11 September 2020

TfNSW Reference: SYD12/00072/58

Council Reference: SSD 7628 MOD 3

**RESPONSE TO SUBMISSIONS FOR MOOREBANK PRECINCT EAST STAGE 3
MODIFICATION - MOOREBANK AVENUE, MOOREBANK**

Figure 2: MARW alignment in relation to MPE subdivision lot boundaries (Source: EMM, 2020)

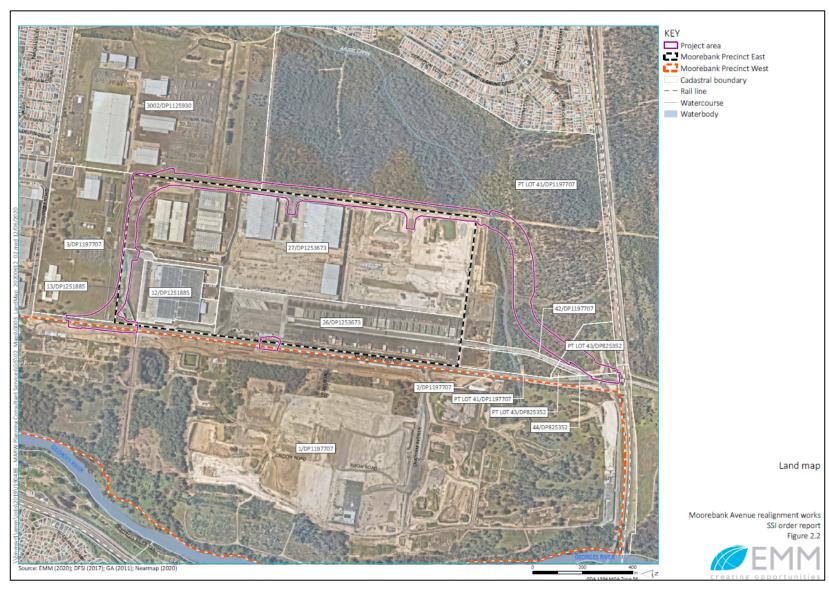
TfNSW has reviewed the submitted information and notes Qube's statement in the Response to Submissions Report that the owner of proposed Lot 42 DP 1197707 and Lot 44 DP 825352 will be SIMTA ie. The Trust Company Limited, which is the current owner of the Moorebank Precinct East land. However, the Response to Submissions also states that there is still potential for the proposed Moorebank Avenue Realignment to encroach on part of proposed Lot 44 DP 825352.

The Proponent is to ensure that any design for these road works will enable dedication of all required land as public road consistent with the Voluntary Planning Agreement, including any encroachment on proposed Lot 44 DP 825352 as has been noted in the Response to Submissions Report.
